REQUEST

Current Zoning: I-1(CD) (light industrial, conditional) and R-22MF (multifamily residential)
Proposed Zoning: I-1(CD) (light industrial, conditional) and I-1(CD) SPA (light industrial, conditional, site plan amendment)

Approximately 9.54 acres located north of Perimeter Pointe Parkway, west of Rebecca Avenue, and south of West Boulevard.

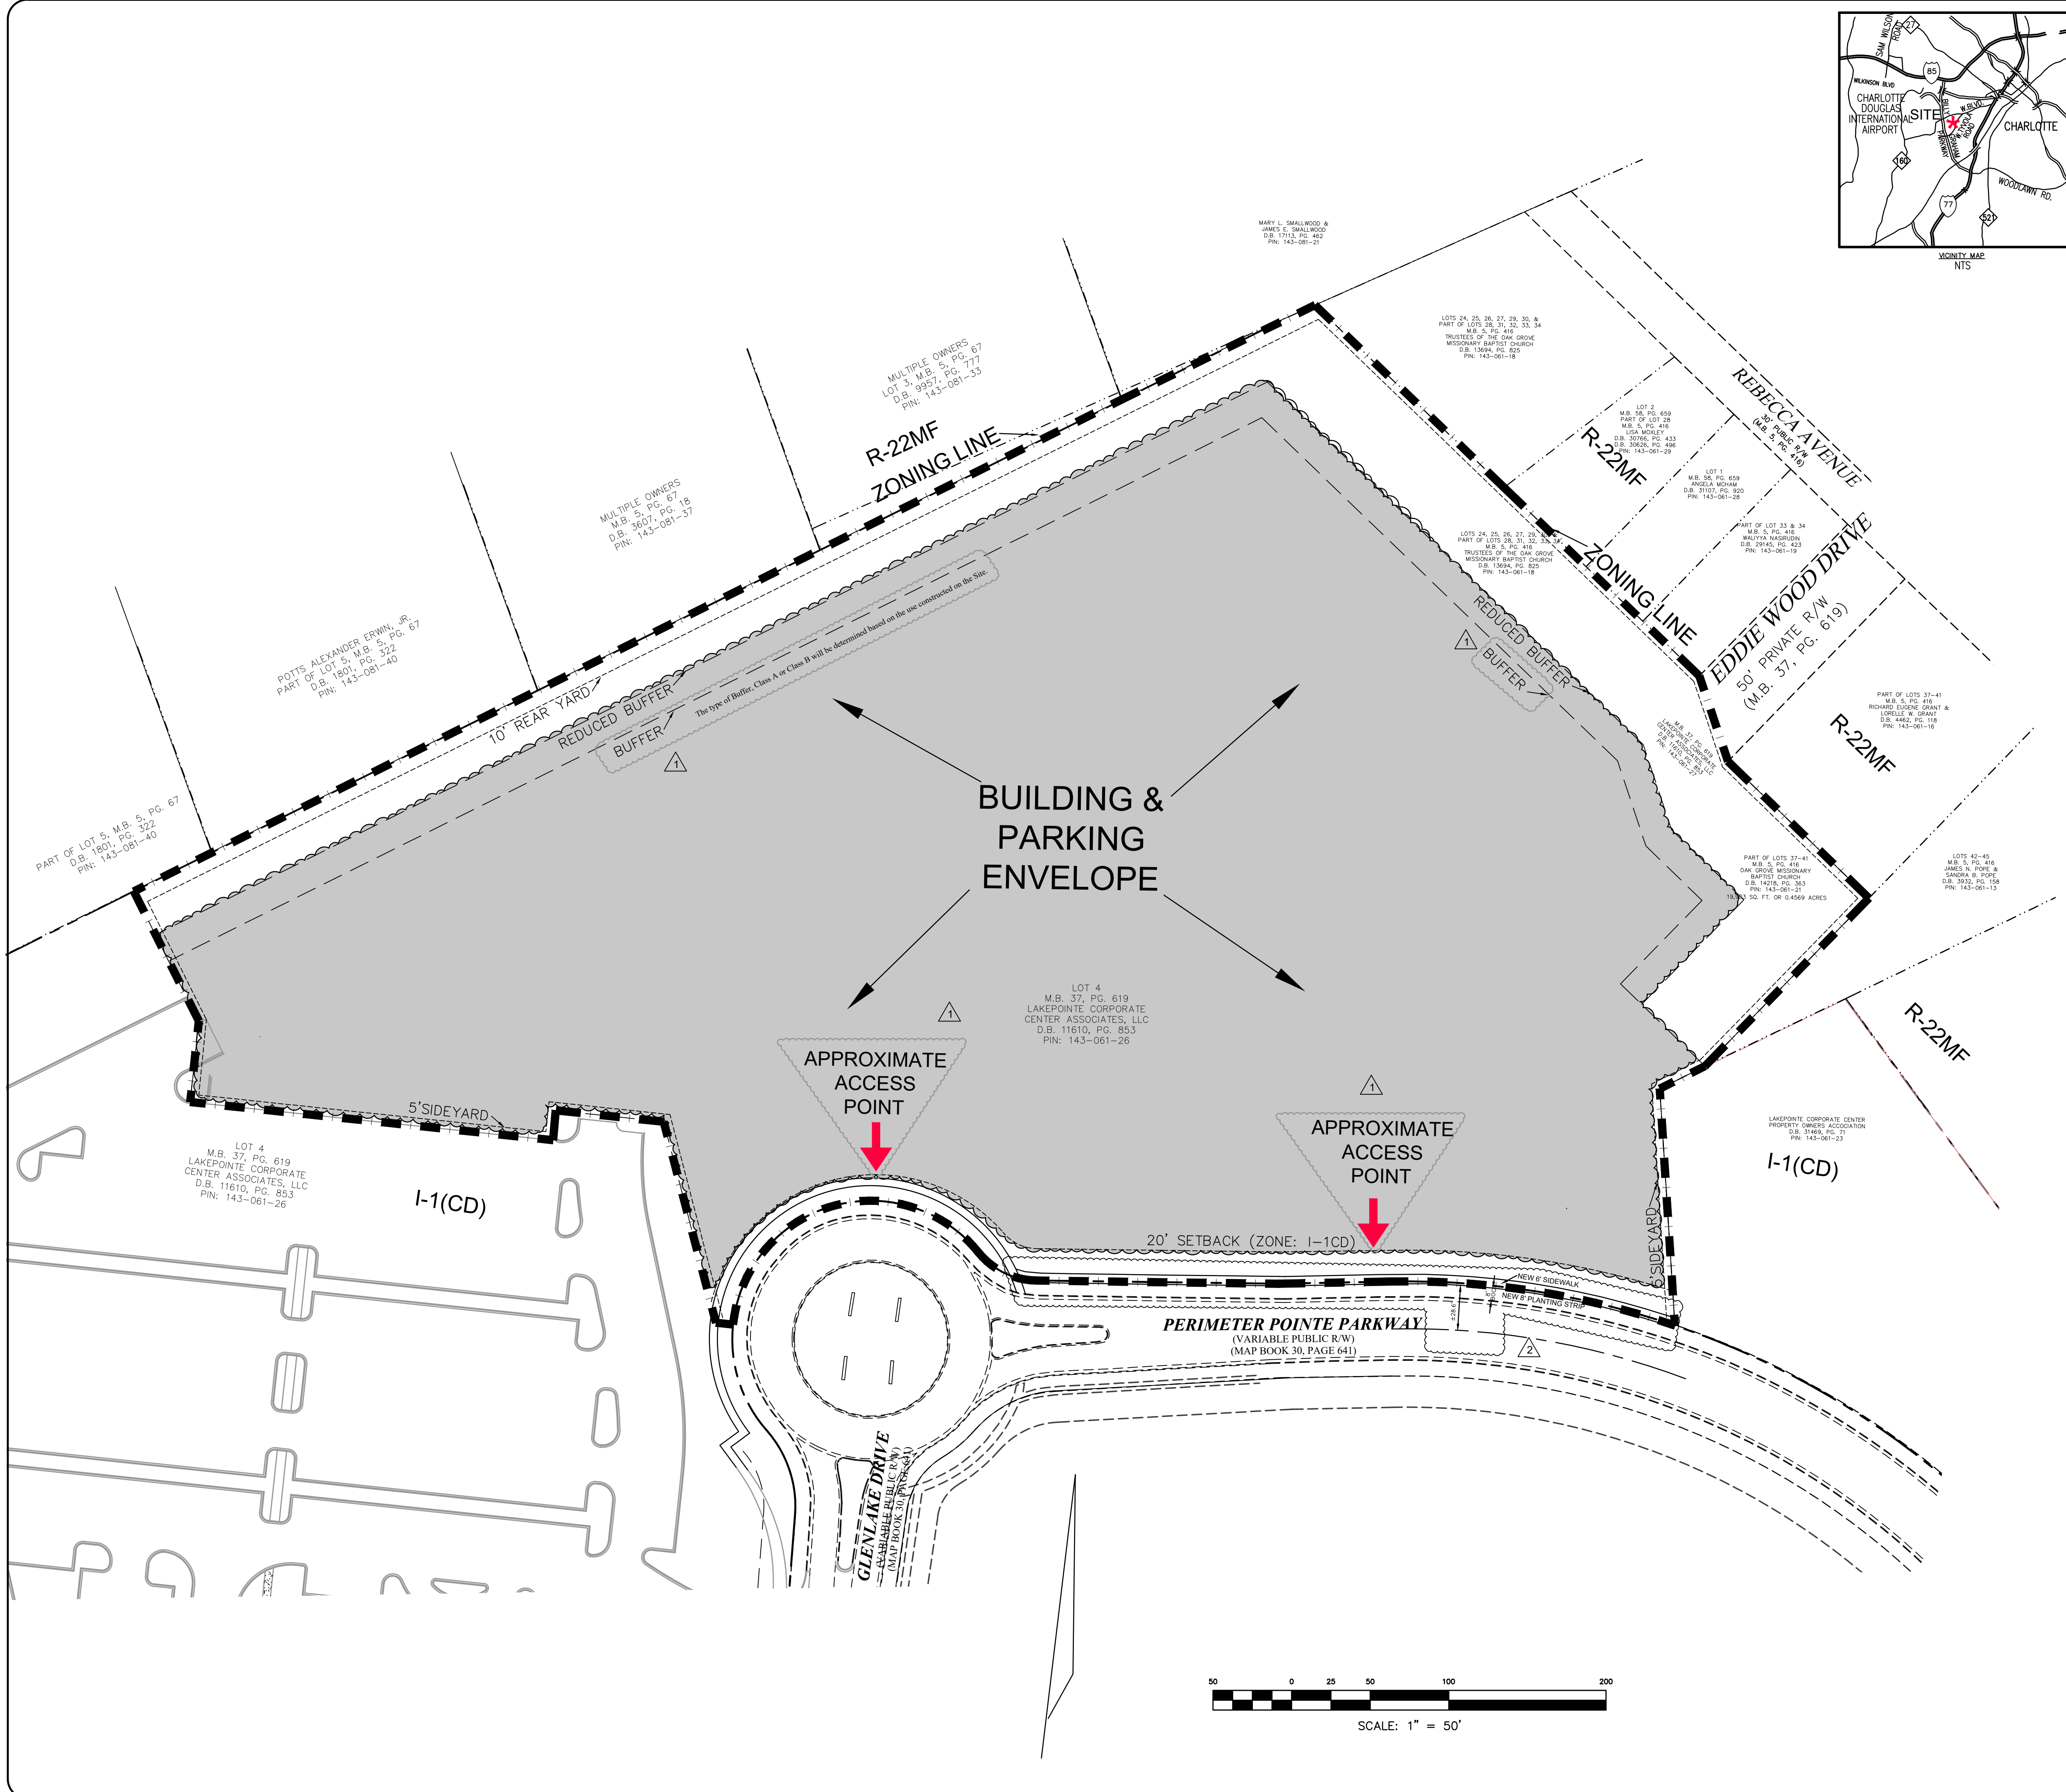
1. ~~Revise the site plan and conditional note(s) to commit to construct an 8-ft planting strip, and 6-ft sidewalk on Perimeter Pointe Parkway as per Charlotte WALKS. This sidewalk need to tie into the existing network at the adjacent parcel, 14306125, and extend to the curb ramp at Tyvola Road. Label and dimension both items from the back of curb and gutter and road centerline. CDOT strongly suggests the 8-foot planting strip and sidewalk be extended east, along Perimeter Pointe Parkway, to the existing curb ramp at Tyvola Road. The adjacent, undeveloped, parcel is listed as common open space, in the Mecklenburg County Tax Records, for the Lake Pointe Corporate Center and is not subject to further development. **ADDRESSED**~~

2. ~~Revise the site plan and conditional note(s) to clarify access point(s). The petitioner should have at least one access point that stems off the roundabout, creating the third leg. Turning movements should be performed to ensure the roundabout may function for the petitioner's design vehicles. **ADDRESSED**~~

3. ~~Add a conditional note to clarify these turning movements will be shown during the permitting process. **ADDRESSED**~~
4. ~~Revise the site plan to add a note specifying all transportation improvements will be approved and constructed before the site's first building certificate of occupancy is issued. The petitioner may phase transportation improvements if said improvements and phasing are explicitly described in site plan notes. **ADDRESSED**~~
